# MDT-PUDSP21010-R2-GEC.pdf Markup Summary

**Subject:** Callout  
**Page Index:** 1  
**Date:** 1/18/2022 9:00:35 AM  
**Author:** dsdparsons  
**Color:** ■  
**Layer:**  
**Space:**  
**Page Label:** [1] 1 COVER SHEET

EARLY GRADING & EROSION CONTROL PLANS  
 GRANDVIEW RESERVE FILING NO. 1  
 FOR  
 HR GREEN

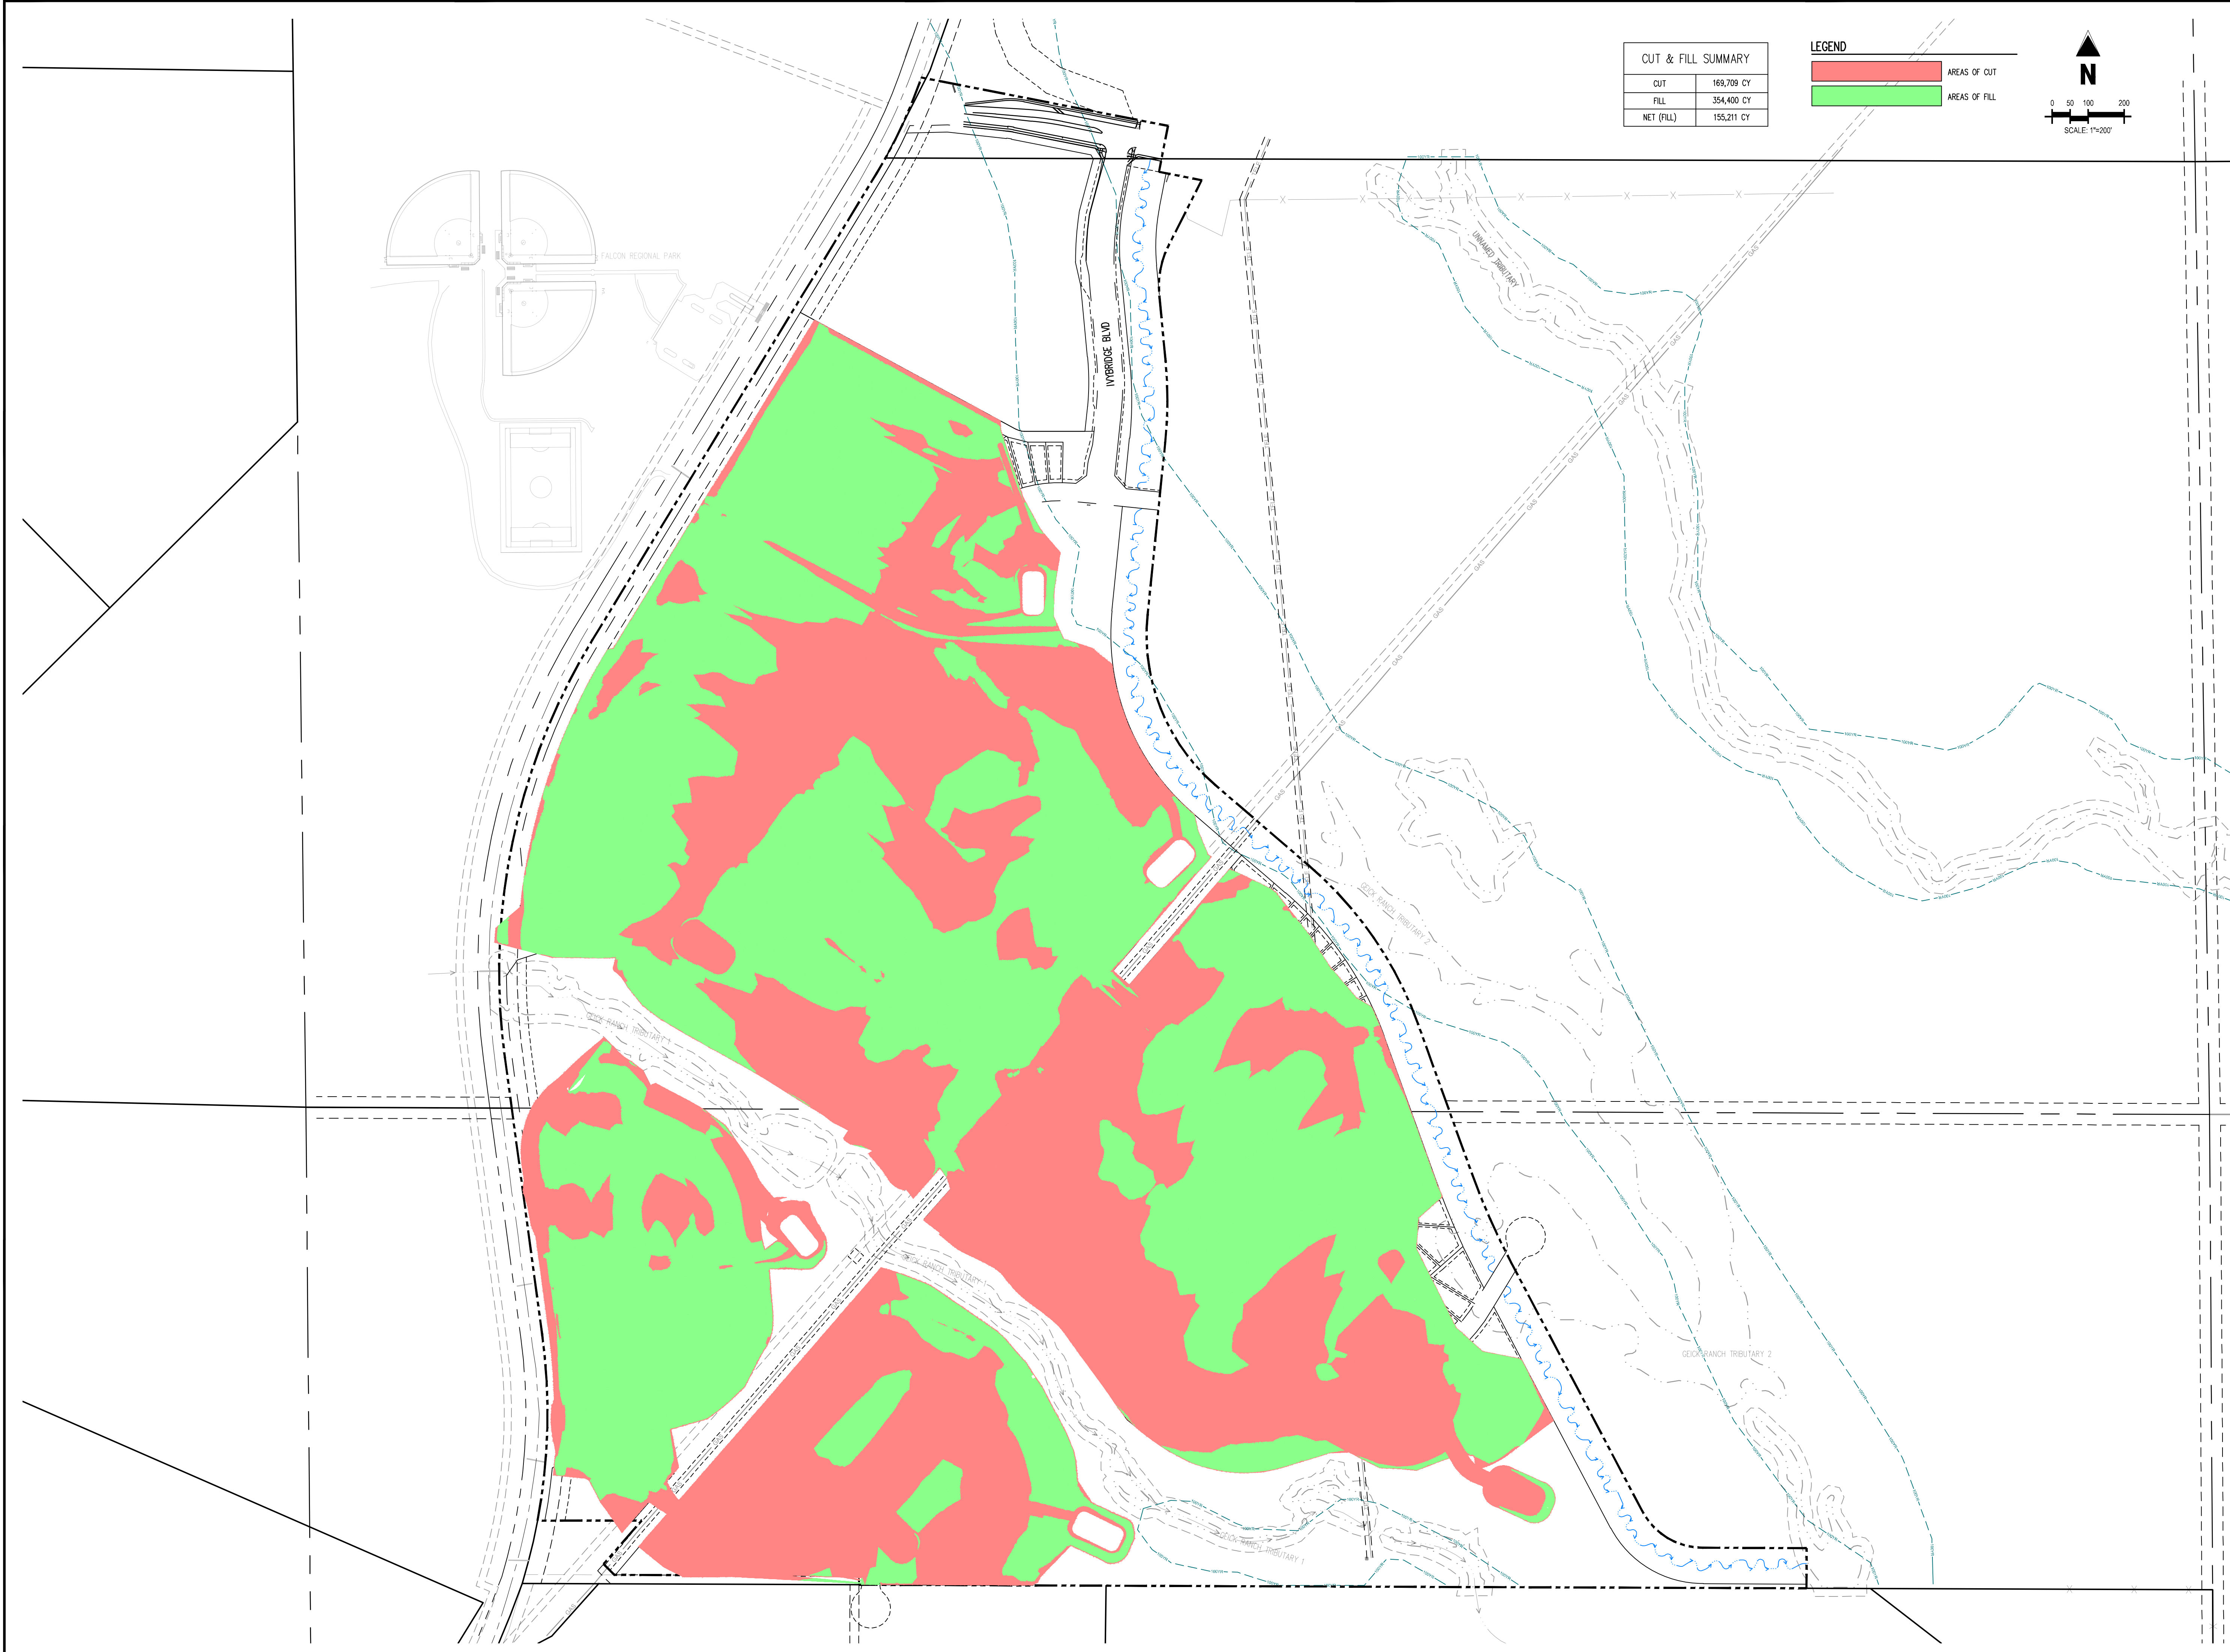
Unresolved Comment from Review #1: Checklist Item "p" - Delineate areas of cut/fill (typical all plan sheets)

V2 Update: You said in your comment responses that you added it in but I am not seeing it. If it's there, the linetype is not labeled on the plans or shown in the Legend. As an alternative, you can add an entirely new sheet dedicated to only showing shading/hatching for cut/fill.
